Application Ref:	2025/0937			 Ribble Valley Borough Council www.ribblevalley.gov.uk
Date Inspected:	N/A	Site Notice:	N/A	
Officer:	EP			
DELEGATED ITEM FILE REPORT:				APPROVAL

Development Description:	Certificate of Lawfulness for proposed rear dormers.
Site Address/Location:	Holly House, 8 Station Road, Rimington BB7 4DR.

SHEET: PROPOSED ELEVATIONS 1

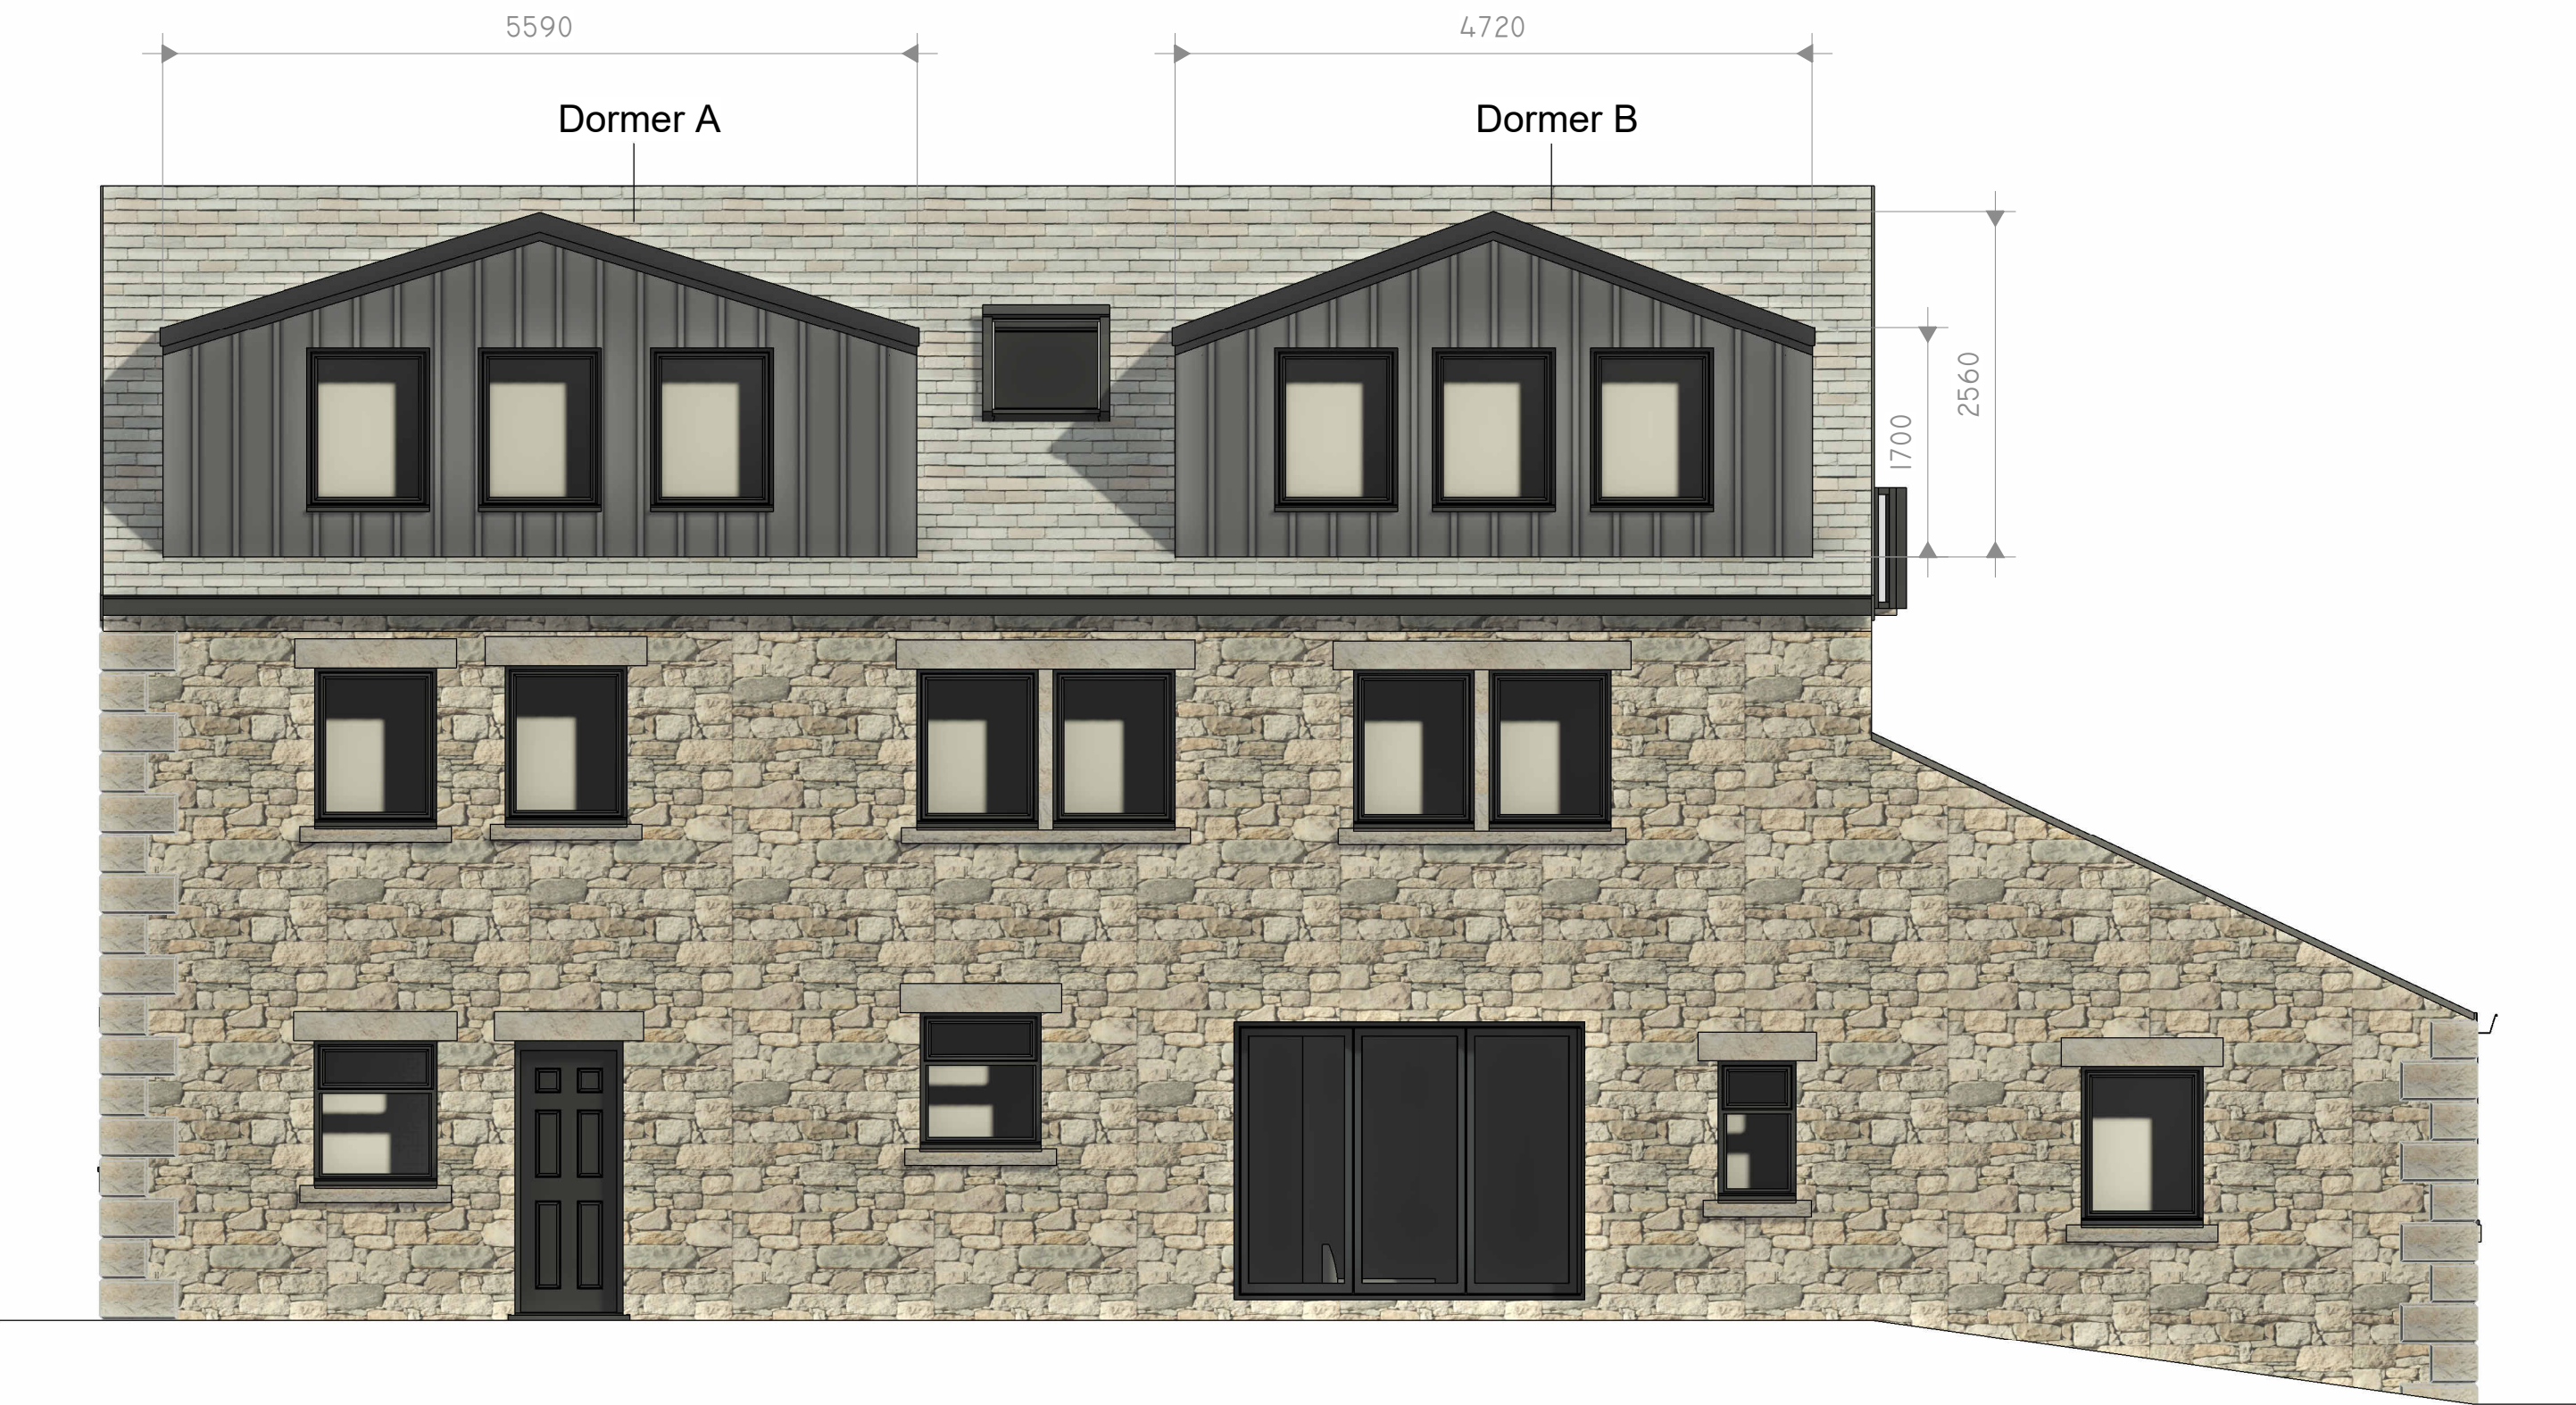
The proposed dormer extension would not extend beyond the plane of an existing roof slope which forms the principal elevation of the dwellinghouse.

The proposed dormer would be constructed in similar materials to the existing dwelling.
